PETER JOHNSON BUILDING

ACCESS REVIEW

Morris-Goding Accessibility Consulting

25th March 2009

Level 2 - Podium Plan

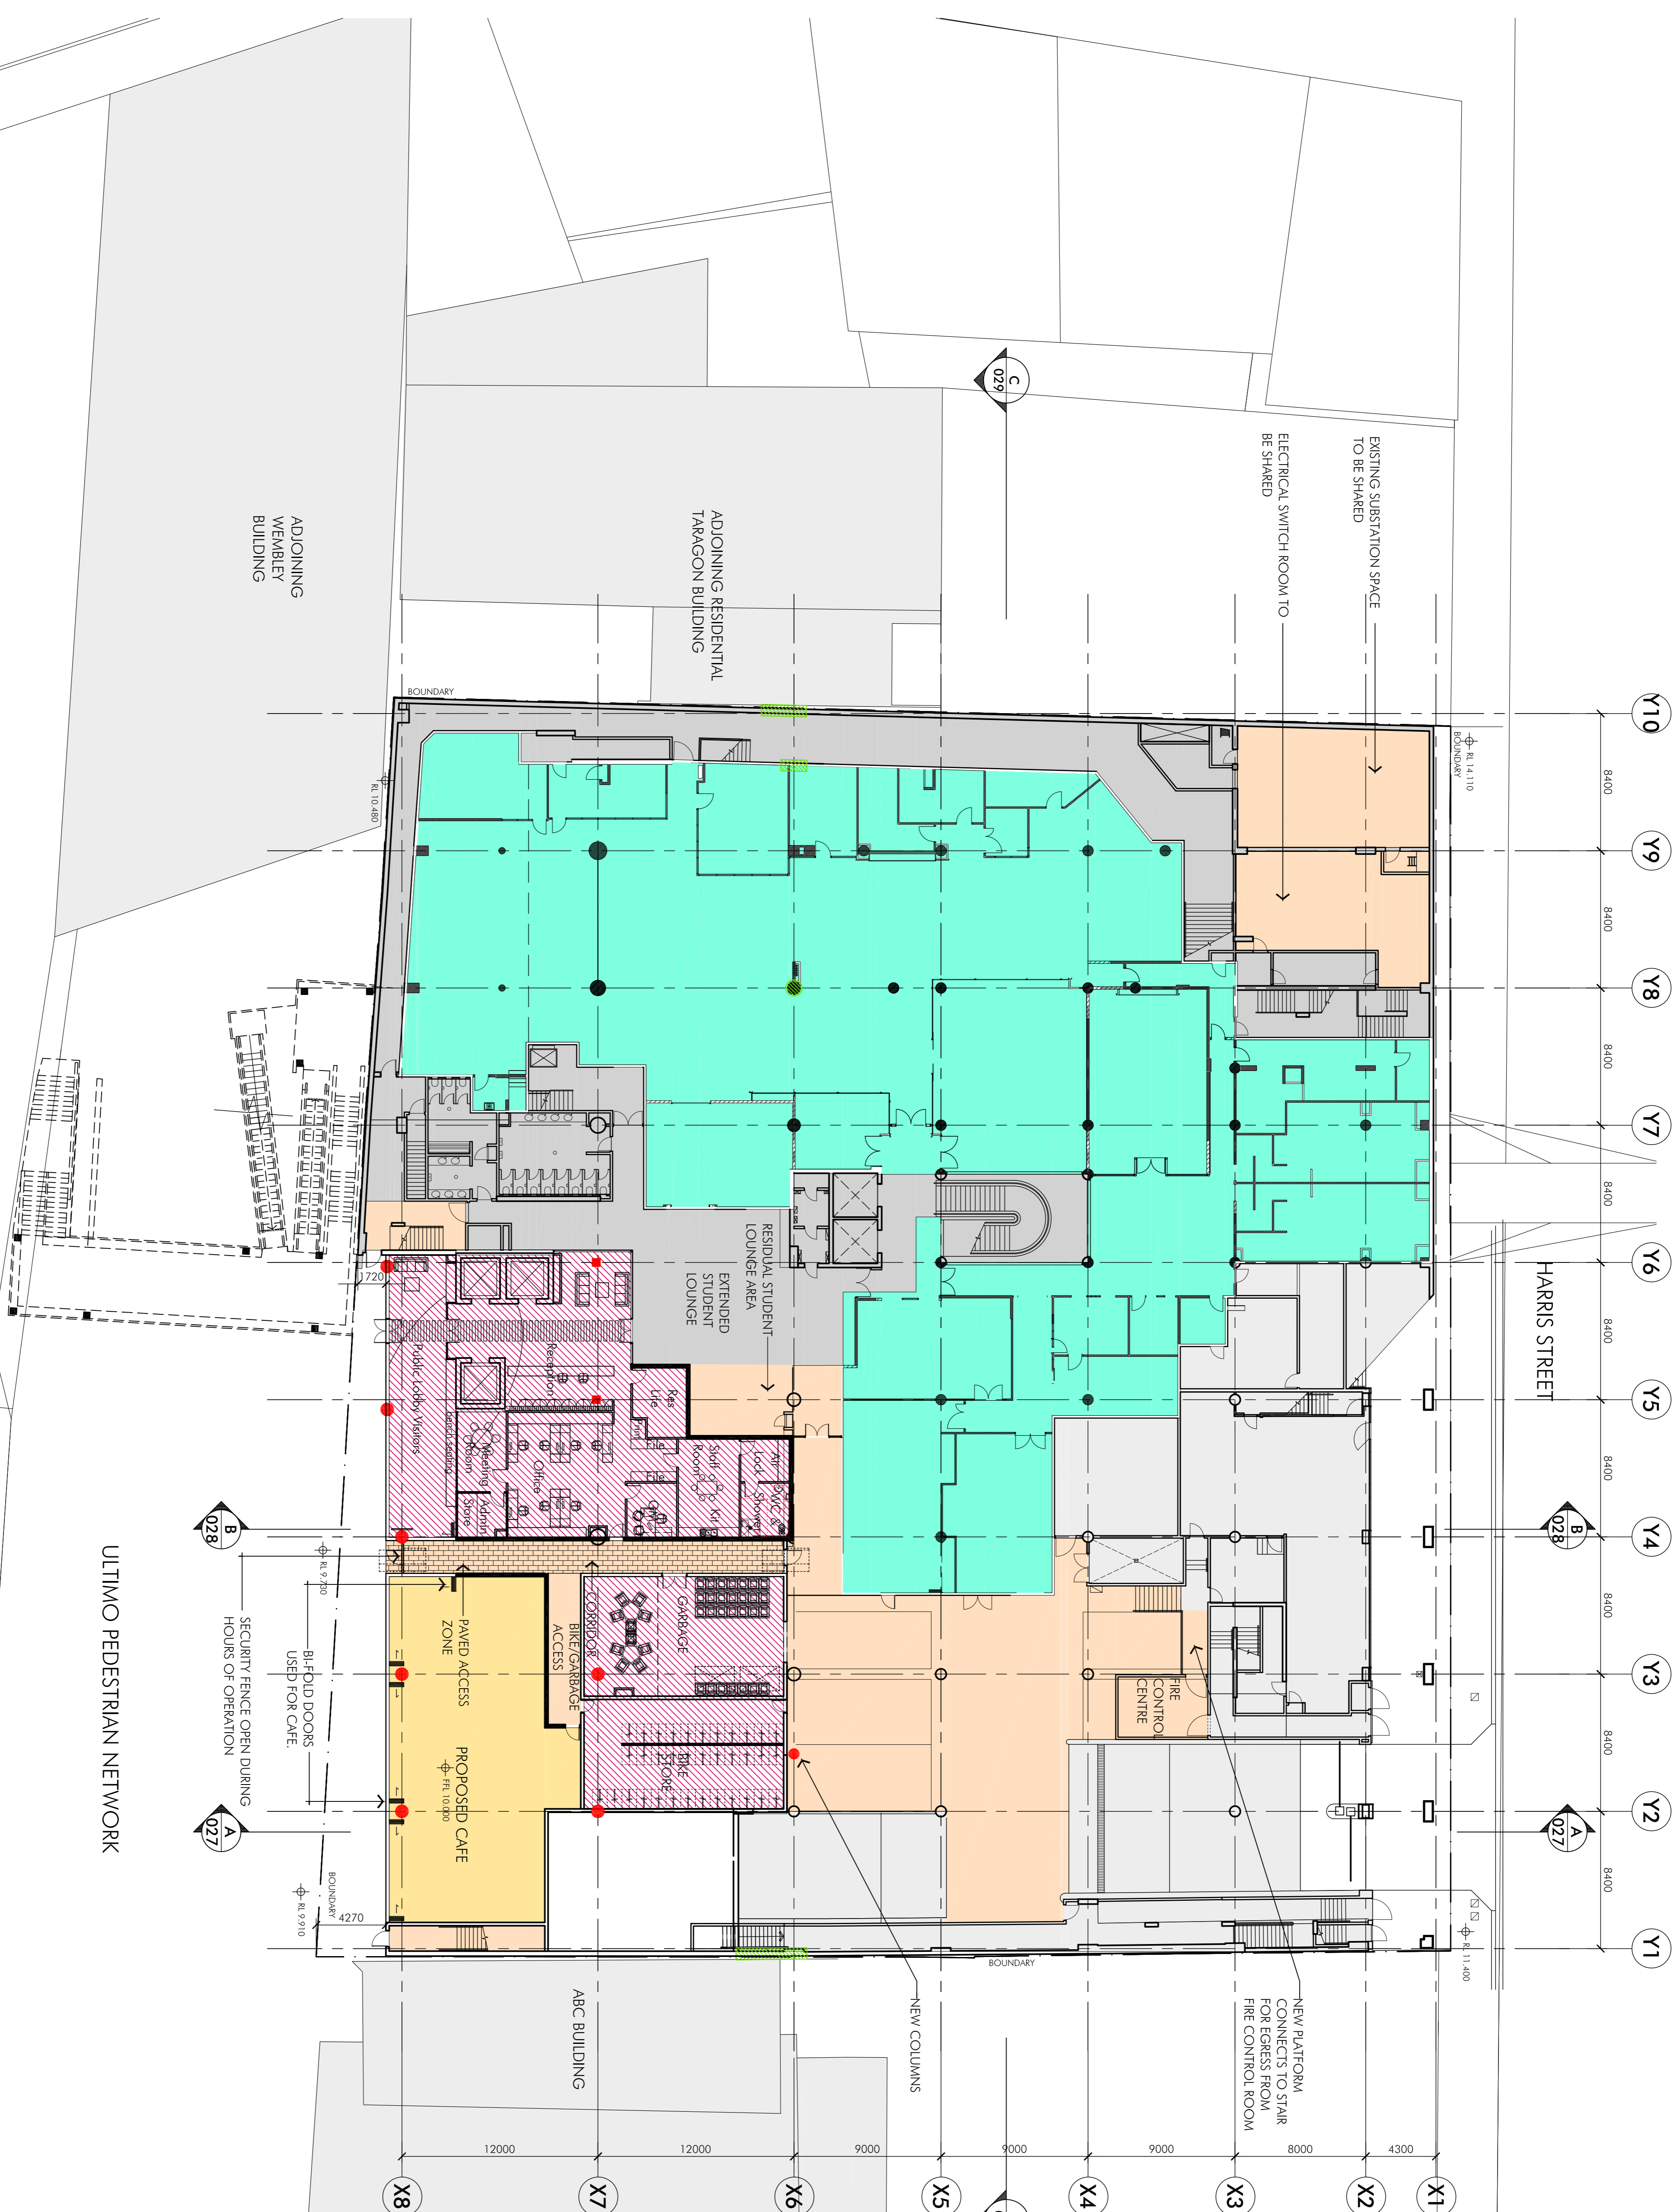
The main entry into the building lobby area is via the use of dual hinged doors, found on the 2nd floor. Each door has 800mm clear width, compliant with AS1428.1.

The primary entry doors shall have a minimum 850mm clear width (920mm door leafs) compliant with AS1428.2 and the UTS Design Guidelines - access criteria 24.4.1.7. This can be achieved.

There is an accessible entry from the Pedestrian Link between the café and lobby entry (2nd floor) to the student lounge area. This passage also leads to the administrative office space and the existing student lounge. The passage behind the secure fence is wheelchair accessible.

The gate will remain open during daytime hours. From the information provided this gate will be secured after hours only.

Currently the corridor has a 2000mm clear width, appropriate in assisting wheelchair users, compliant with the UTS Design Guidelines.

**Level 4 - Podium Plan**  
1:200 @ A1, 1:400 @ A3  
20th March 2009  
3531\_DA006

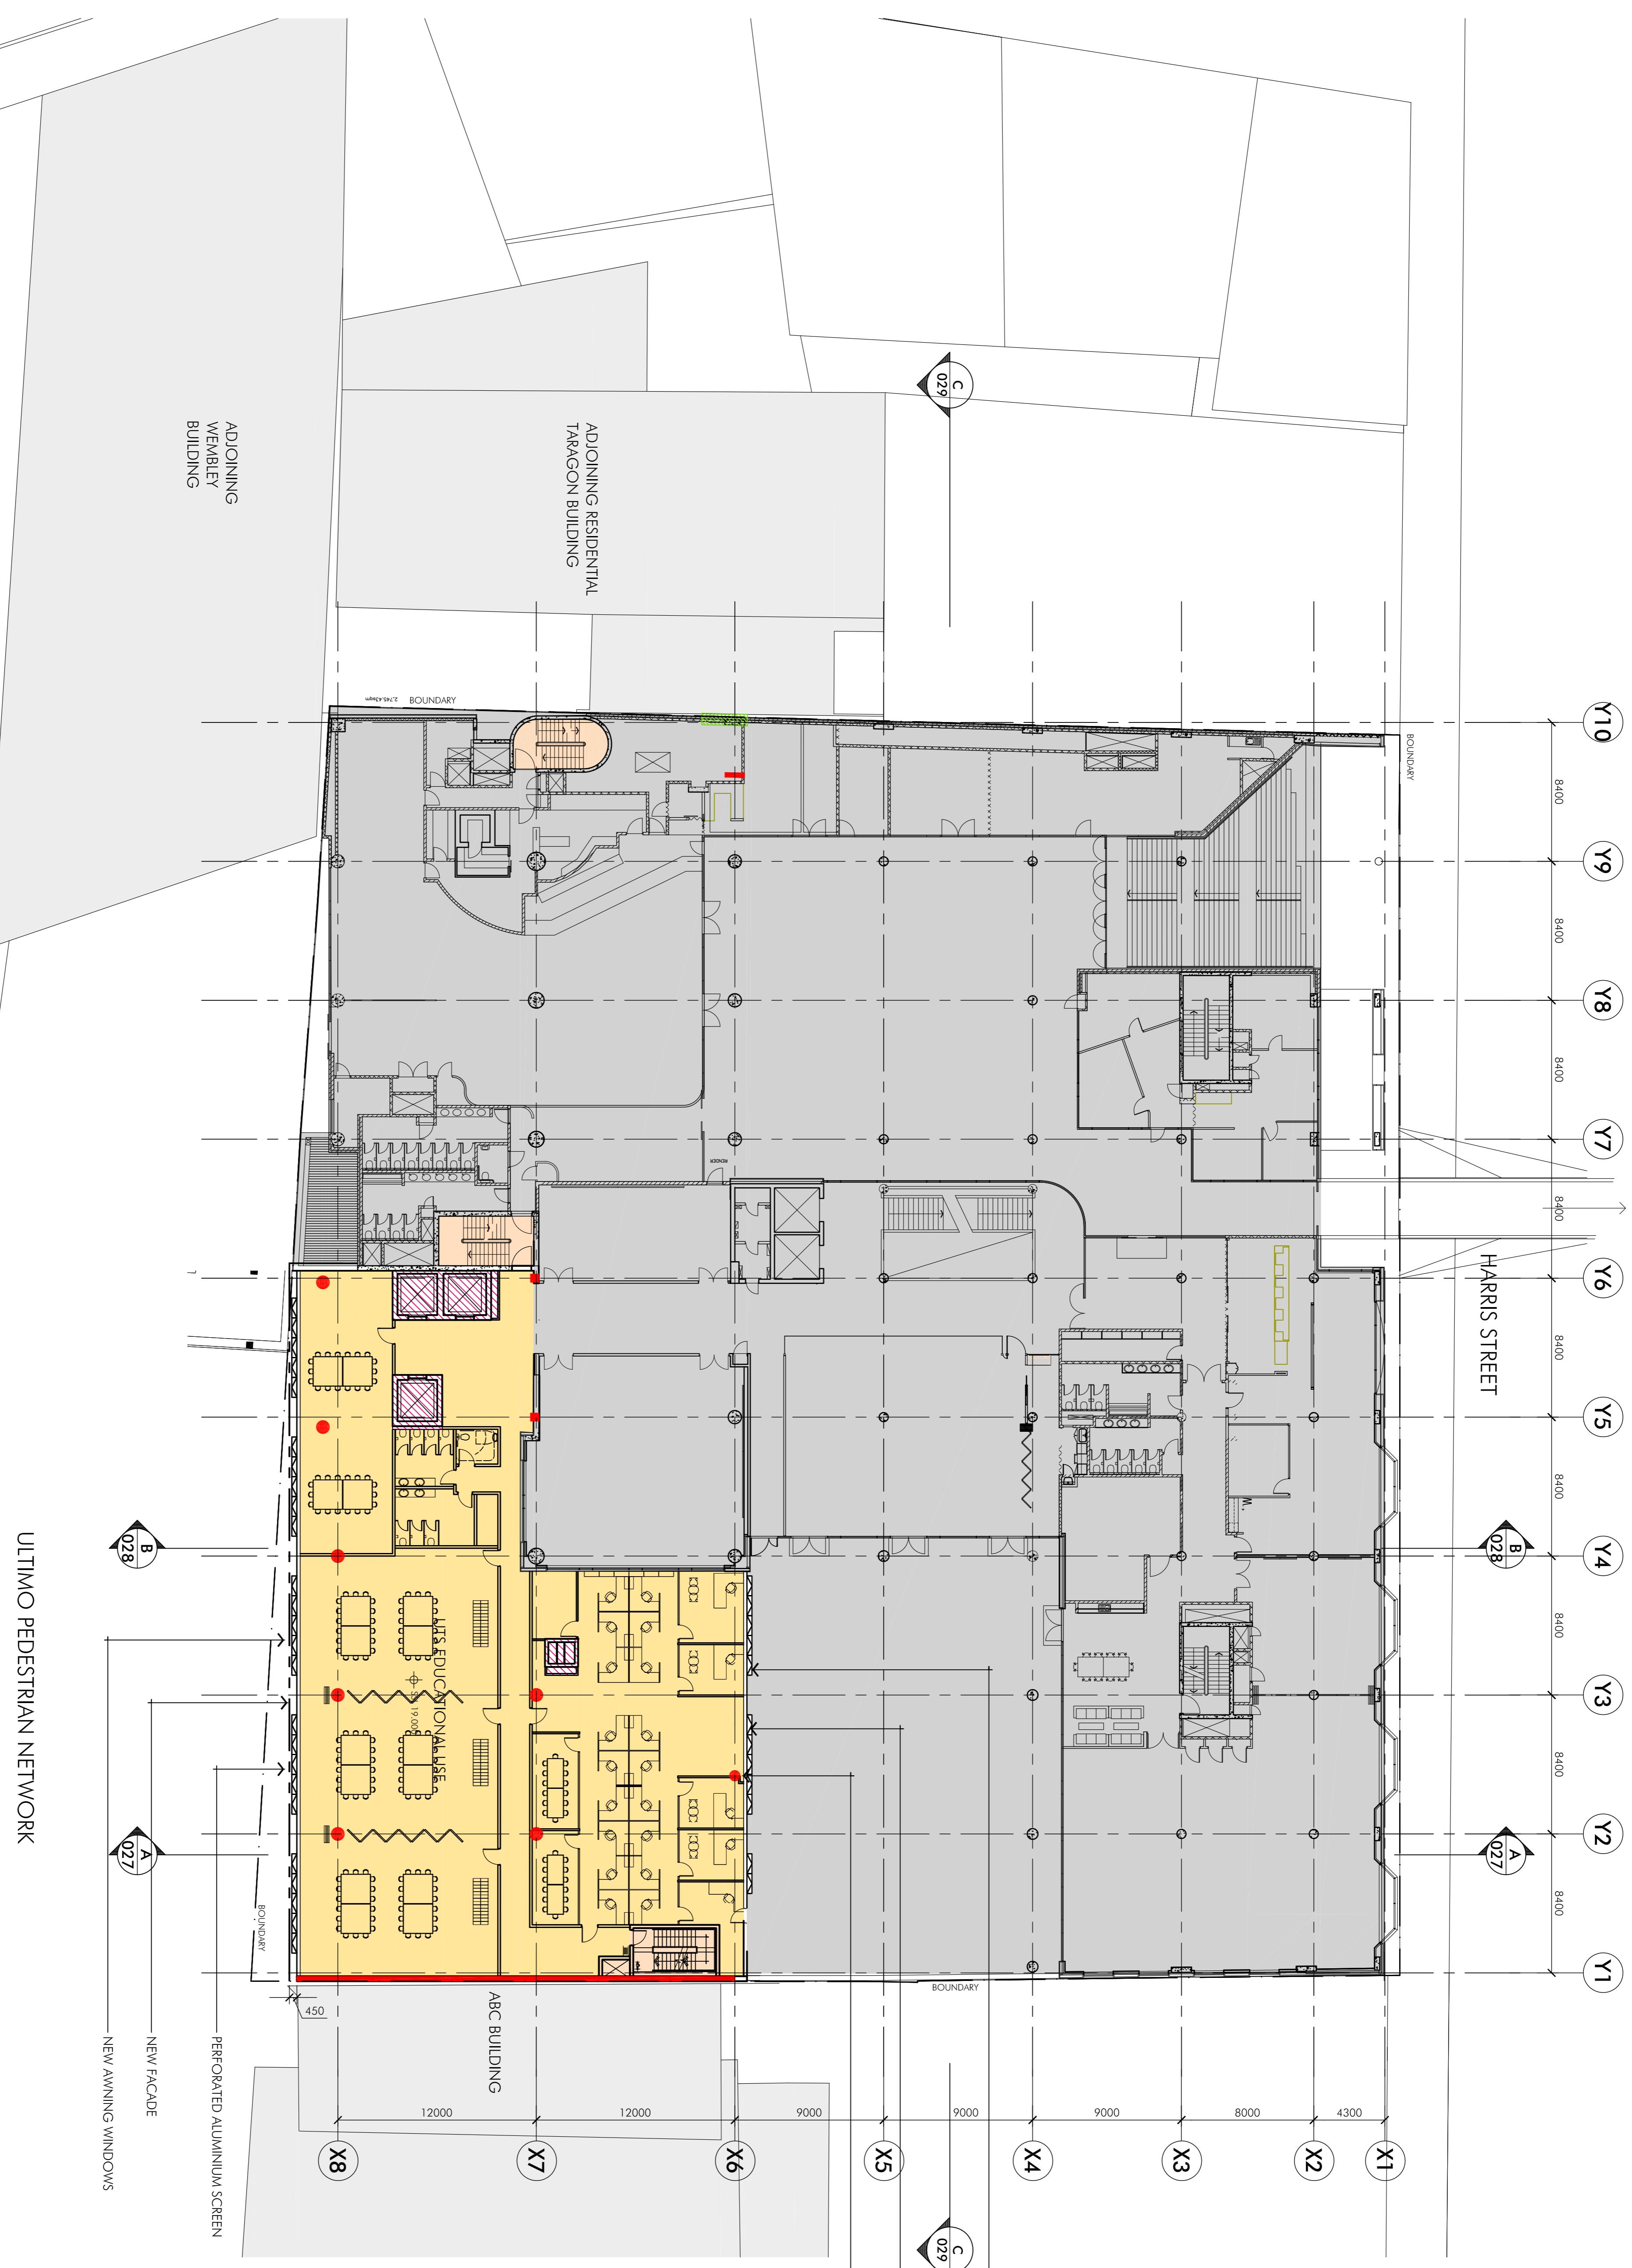
3.3. Harris Street Level 3 Entry

Wheelchair access has also been made available via the use of a ramp found along the east end of the building (level 3). The 1200mm wide dog leg ramp measures 1000mm between handrails, compliant with BCA and AS1428.1. The ramp has 1200mm long mid landings at 6m interval compliant with AS1428.2.

Handrails and tactile grounds surface indicators (TGSI) at stairs and ramps, need to be provided under BCA and the UTS Design Guidelines - access criteria section 24.4.1.4. This can be achieved.

Entry into the building is via the use of auto sliding doors. The doors appear to maintain width, compliant with AS1428.2. The circulation spaces around the auto sliding door will allow for appropriate manoeuvrability for wheelchair users. The path of travel from the main entry door to the lift lobby area is appropriate for wheelchair users, compliant with AS1428.2.
